# Comment for planning application 6/2021/2791/HOUSE

| <b>Location</b>           | <input type="text" value="28 Theobalds Road Cuffley Potters Bar EN6 4HQ"/>  |
| <b>Proposal</b>           | <input type="text" value="Conversion of loft to habitable space including roof alterations, the addition of side dormers and the erection of a part first floor and part single storey side and rear extension"/> |

**DPL 03**  
www.discountplanning.com

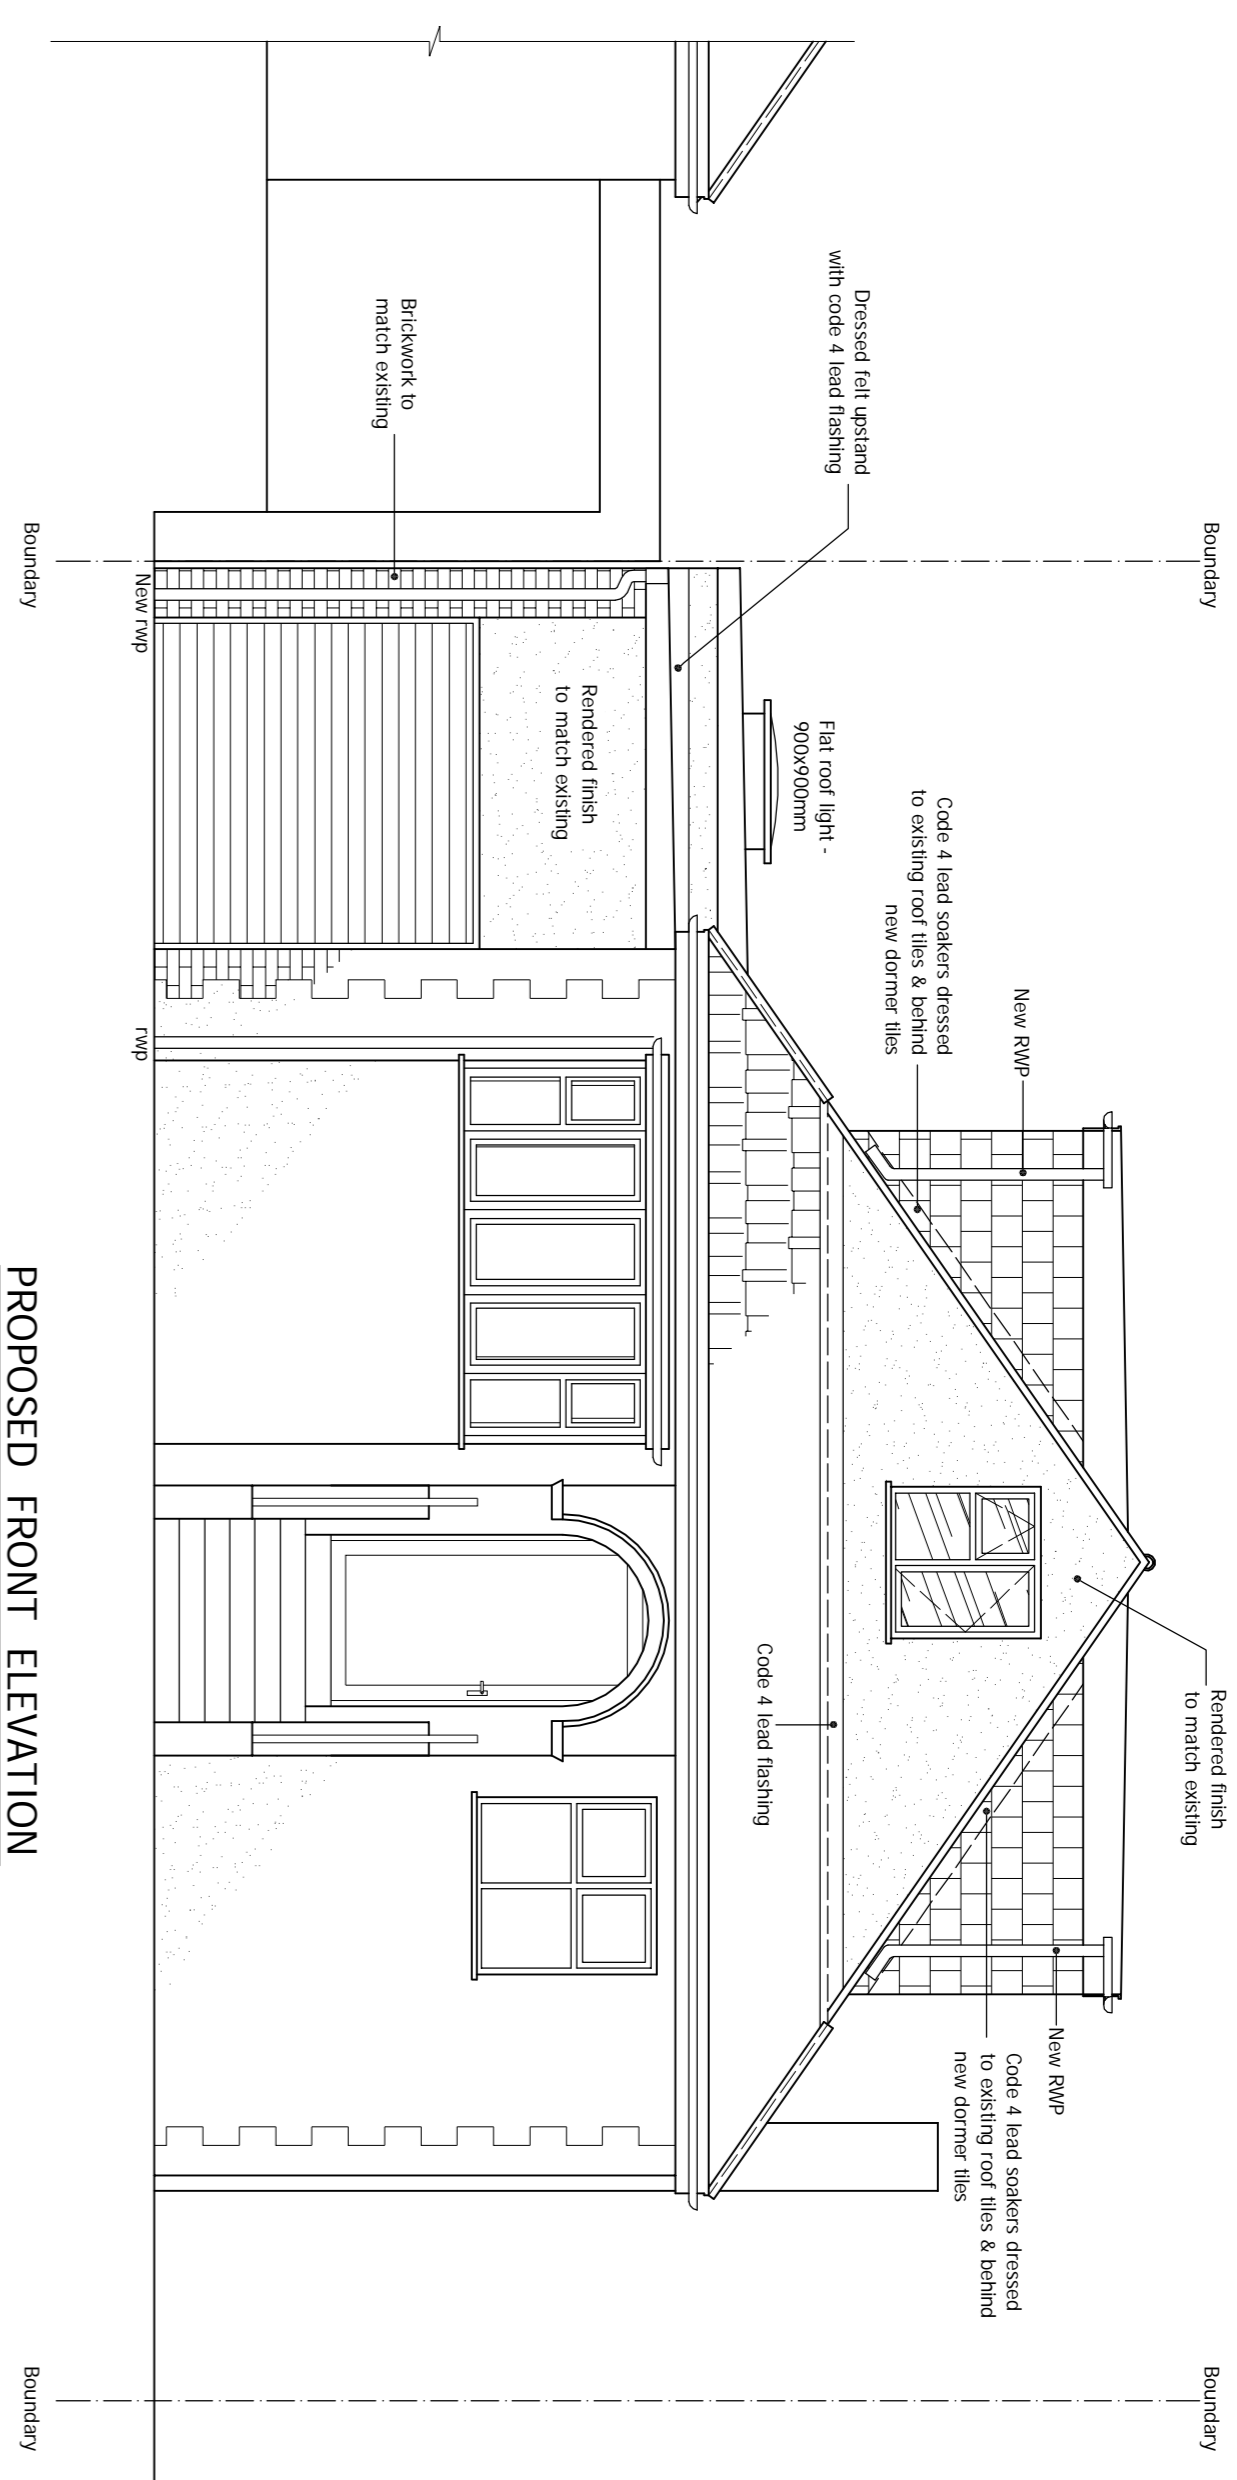
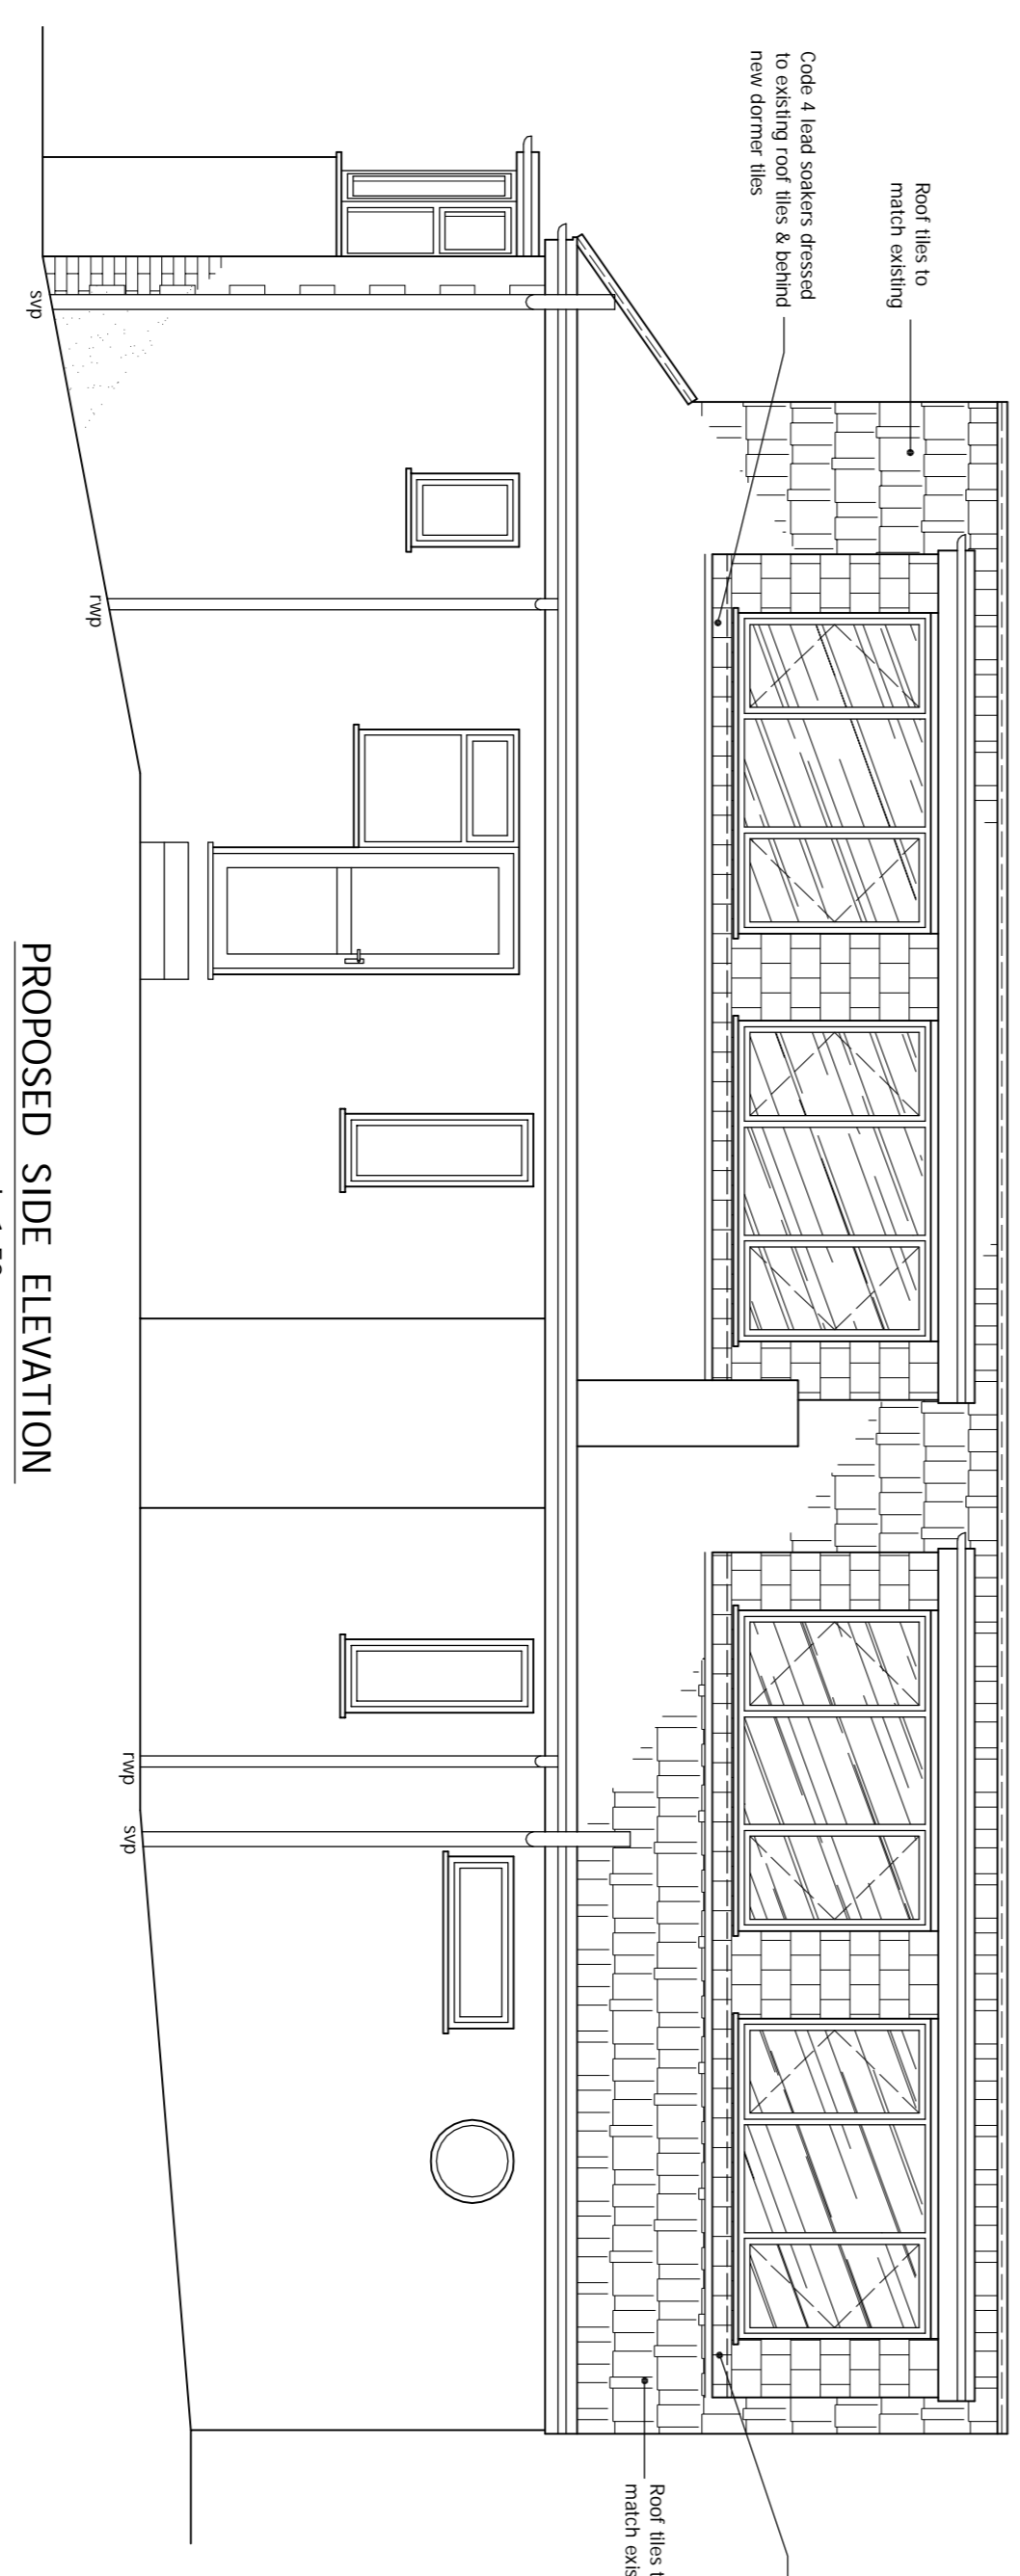
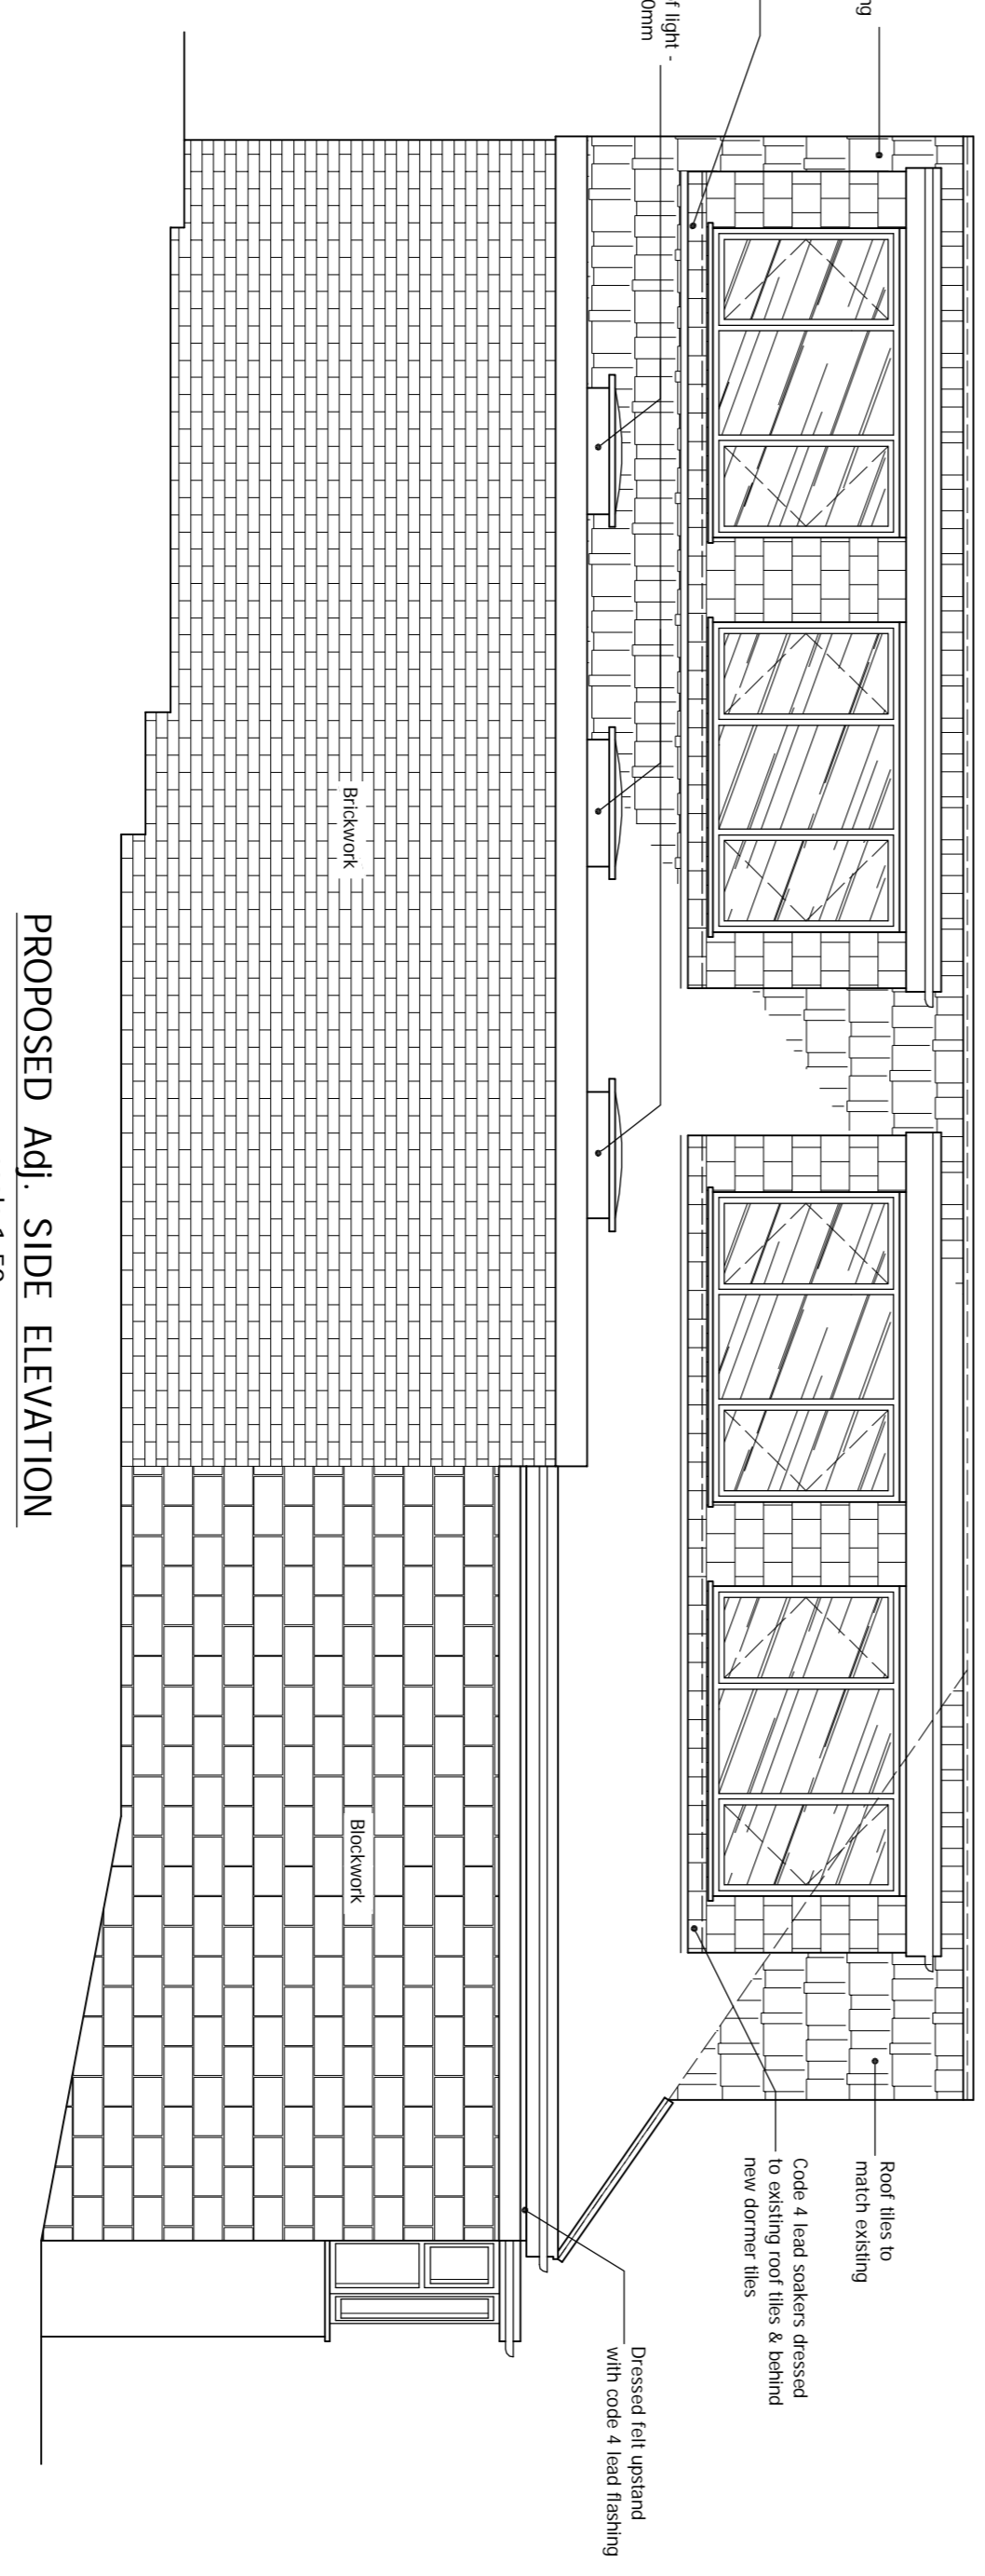
| <b>Comments</b>           | <input type="text" value="No objection in principle, just a concern of privacy by being overlooked from proposed dormer windows and ask that obscure glazing be fitted to these."/>                               |
